Project Name: SEVEN BAR RANCH

City of Albuquerque
Planning Department
Inter-Office Memorandum

TO: Jack Cloud, DRB Chair
FROM: Randall Falkner, Planner
SUBJECT: Project # 1003658

On July 17, 2008, the Environmental Planning Commission approved Project # 1003658 08EPC-40066/40067/40068, a site development plan for subdivision, a site development plan for building permit, and a request to amend site development plan for building permit for Tract D-4-G, Seven Bar Ranch, zoned SU-1 IP, located on NM 528 between Ellison Drive and Corrales Road, containing approximately 9.3 acres.

JACK IN THE BOX
BURLINGTON ON NM 528
ALBUQUERQUE, NM
LANDSCAPE PLAN

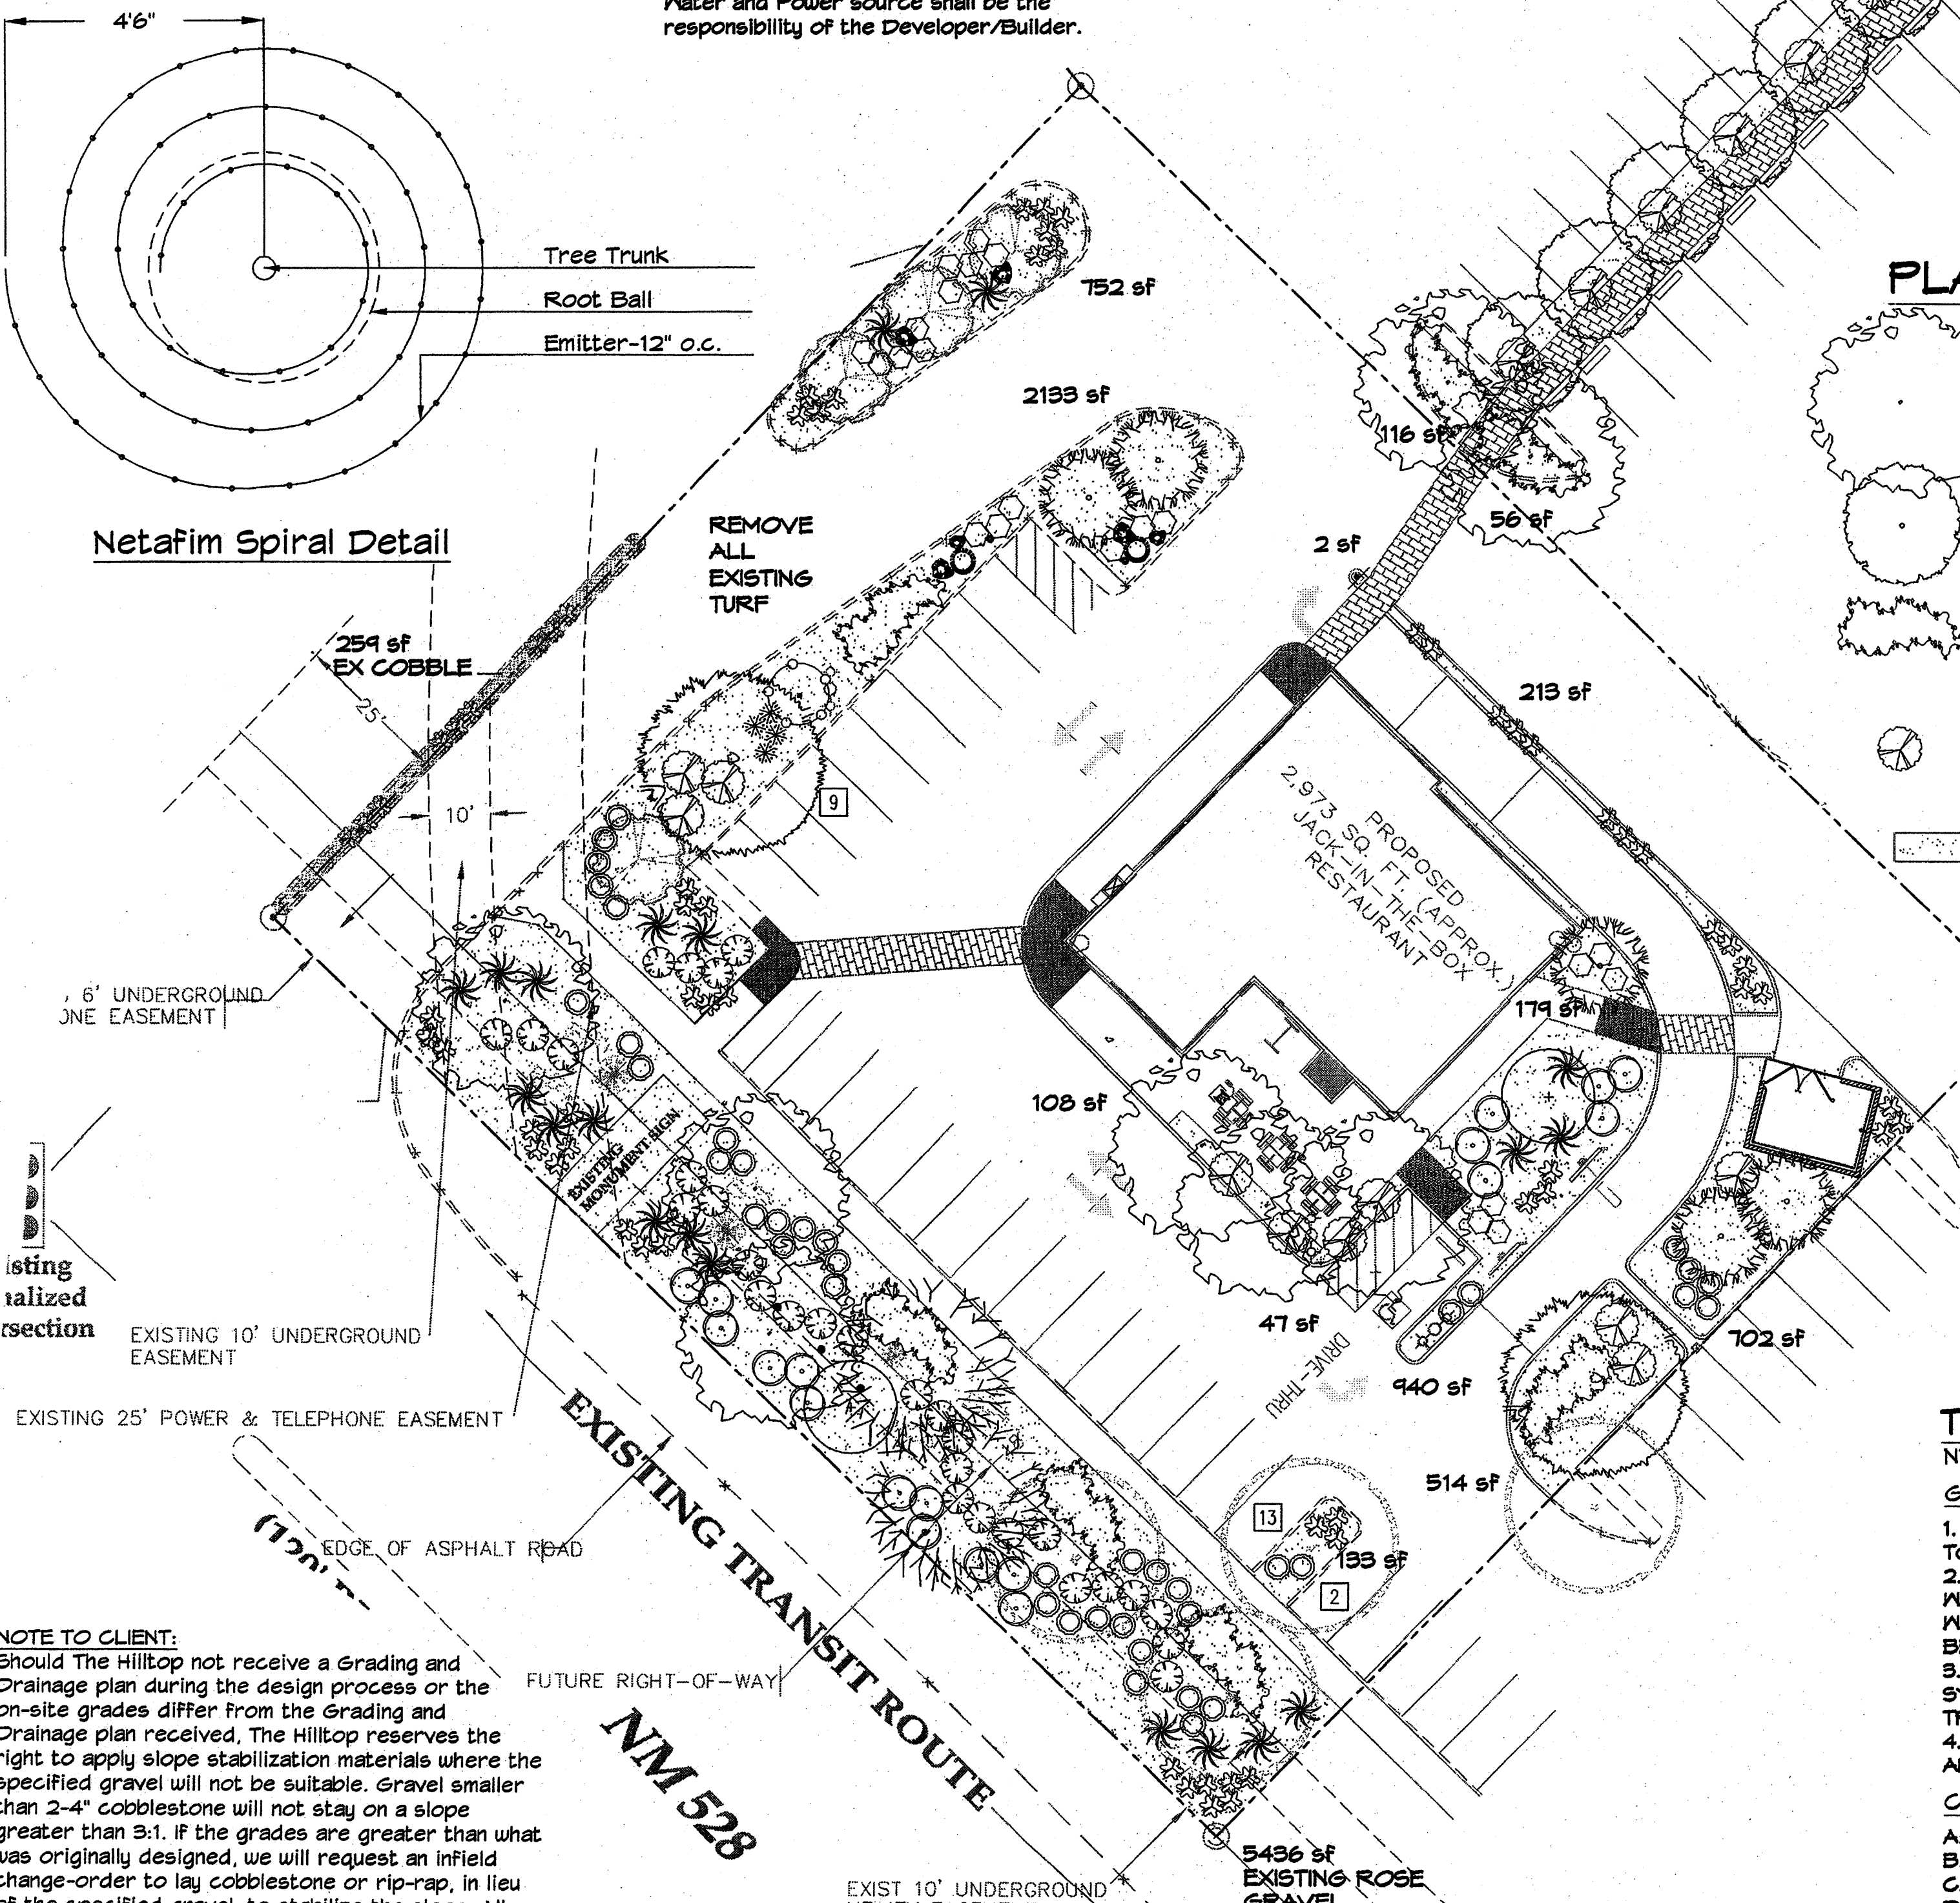
Condition #7 requires that parking spaces be eliminated to create a patio in this area. Only one handicap parking space is required for this facility. A wheel stop has been added to the handicap parking space located on the south side of the building to comply with condition #5.

Condition #6b is a requirement to expand the tree wells for Bur Oaks in the two furthest east tree wells. However, these tree wells are located on the adjoining property and not under the control of the property owner. The trees that were originally depicted in these tree wells have been relocated to the new patio area to help provide 50% shading as described in condition #7.
